Our Ref: EN010115

Date: 22 April 2024

Application by Five Estuaries Offshore Wind Farm Ltd for an Order Granting Development Consent for the Five Estuaries Offshore Windfarm

Advice following issue of decision to accept the application for examination

DRAWING TITLE:  
**2.11  
 Historic Environment Plan - Onshore**

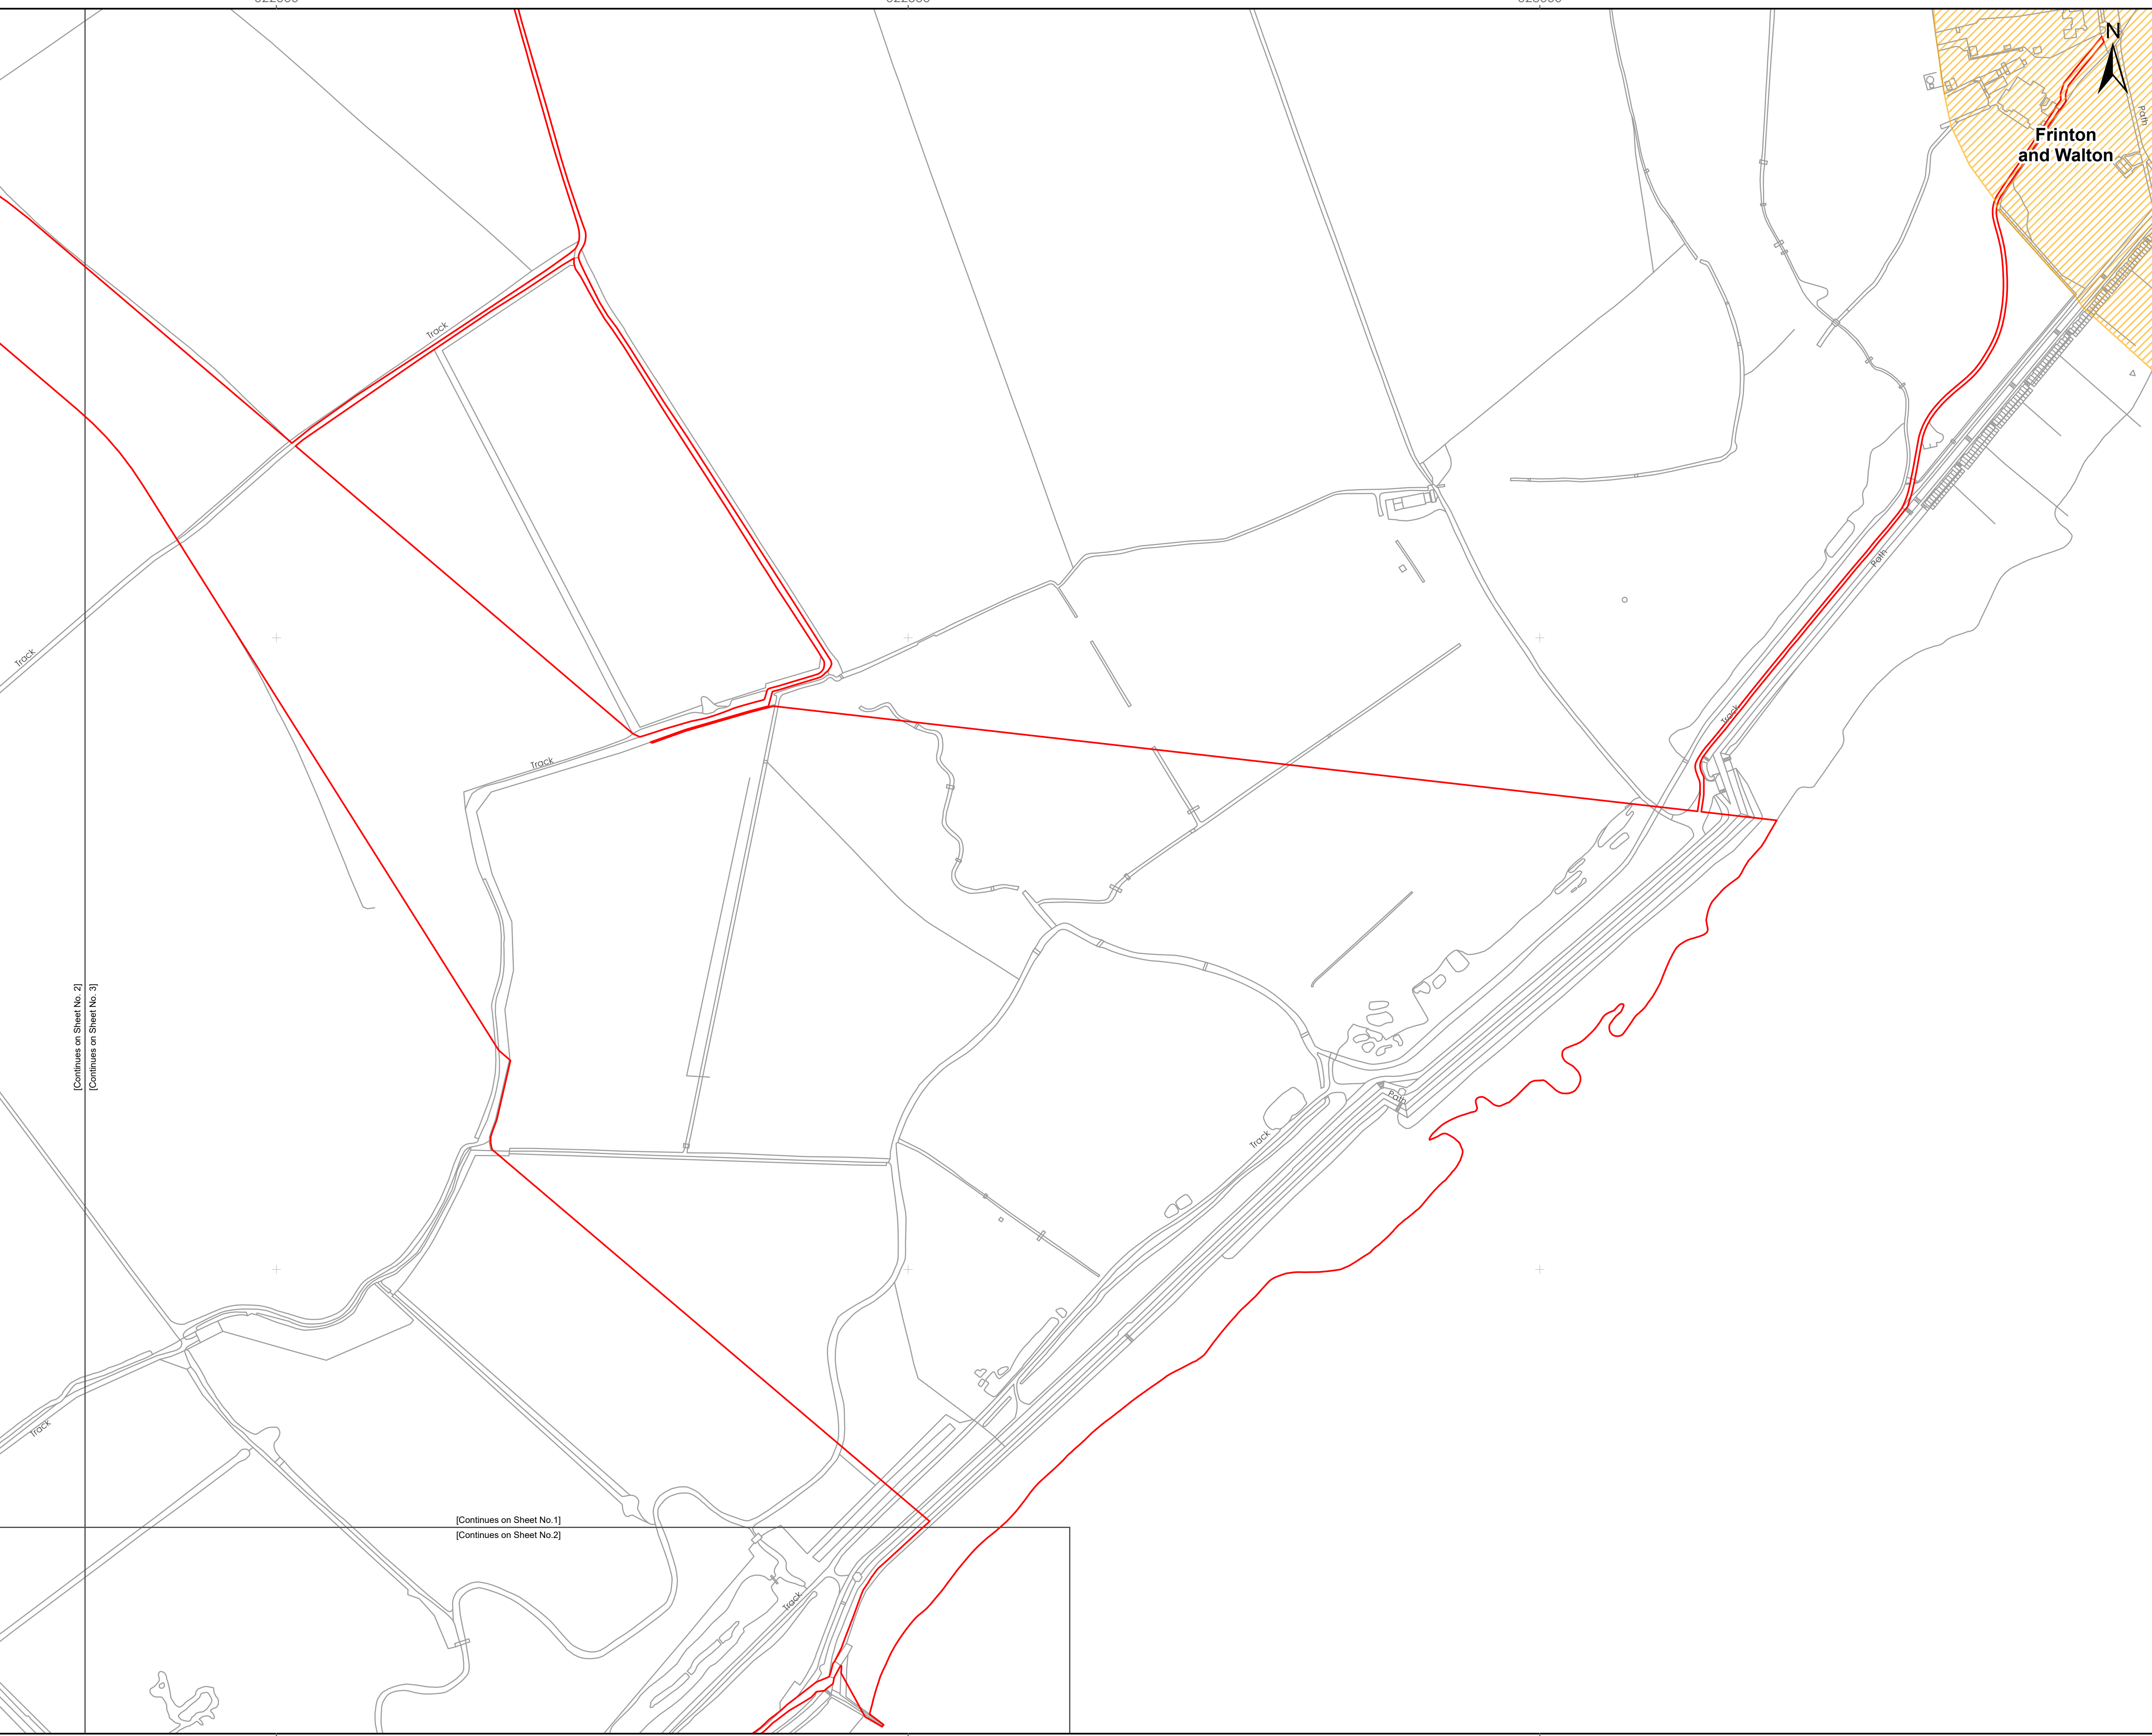
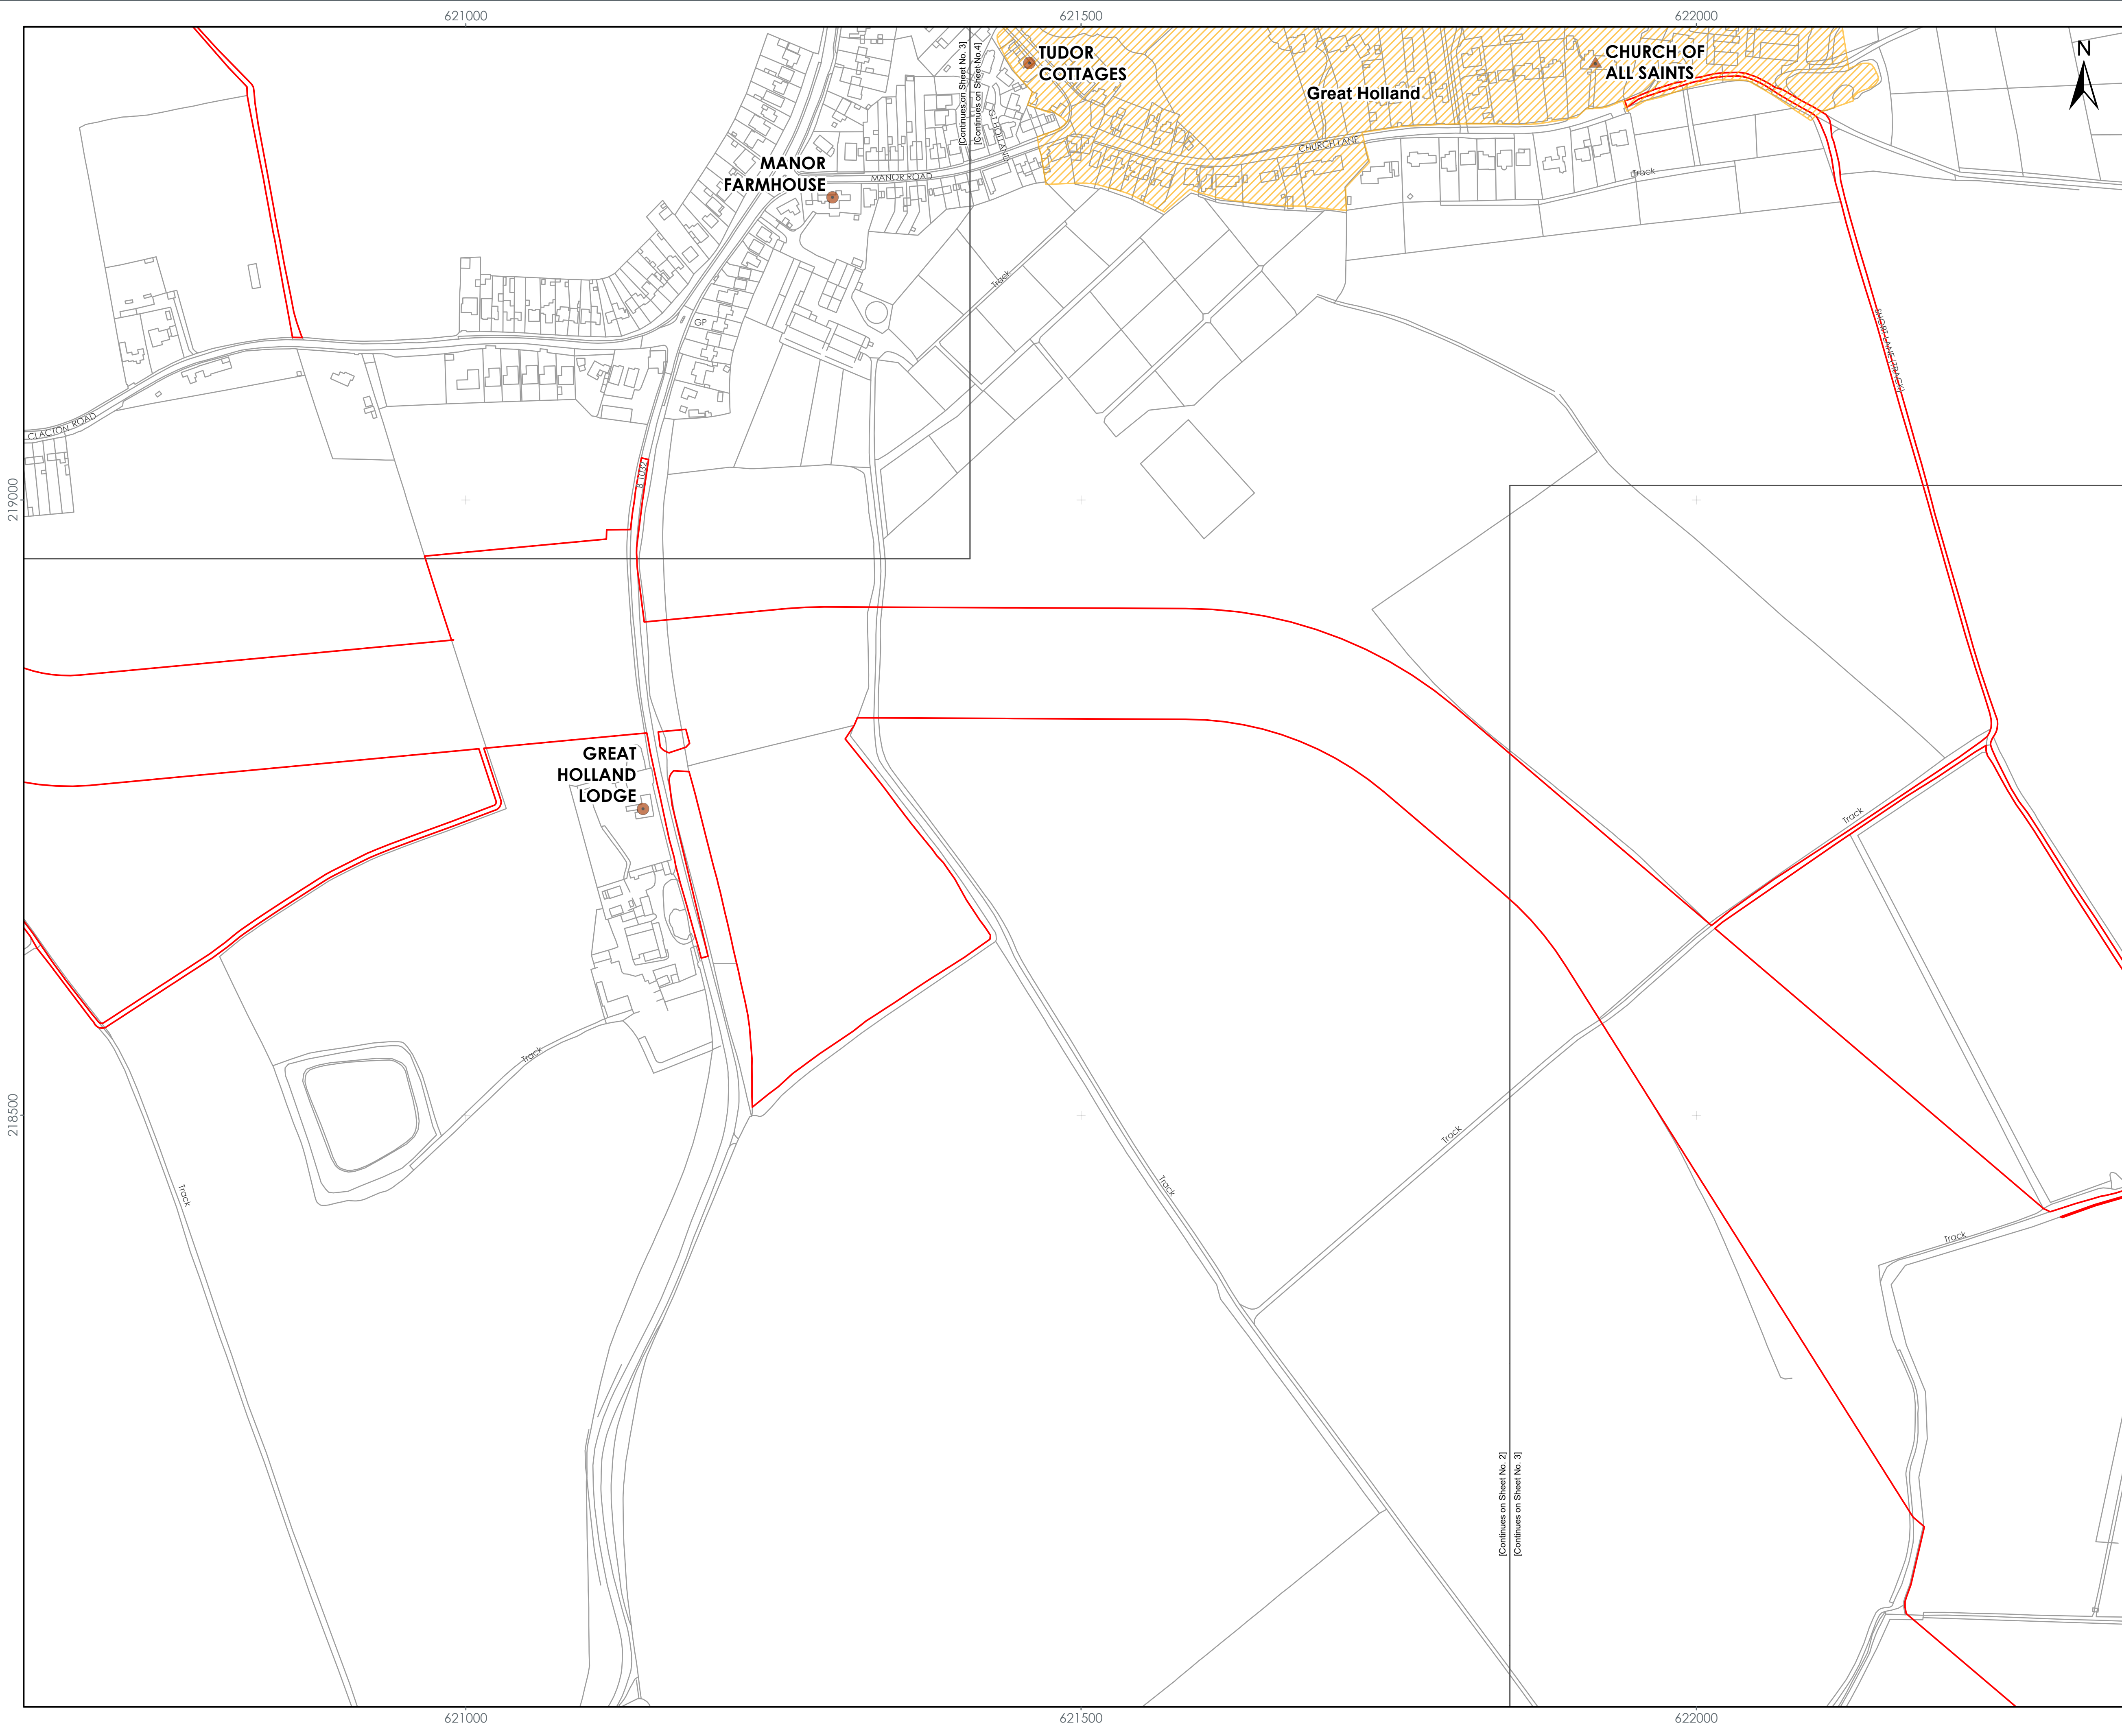
Historic environment plans show a woodland layer on the key, but this is not visible on the plans.

These plans also show ancient woodland which may not be required in the historic environment context and could be included in the **Statutory or Non-Statutory Sites and Features of Nature Conservation - Onshore plans (Doc 2.13)**.
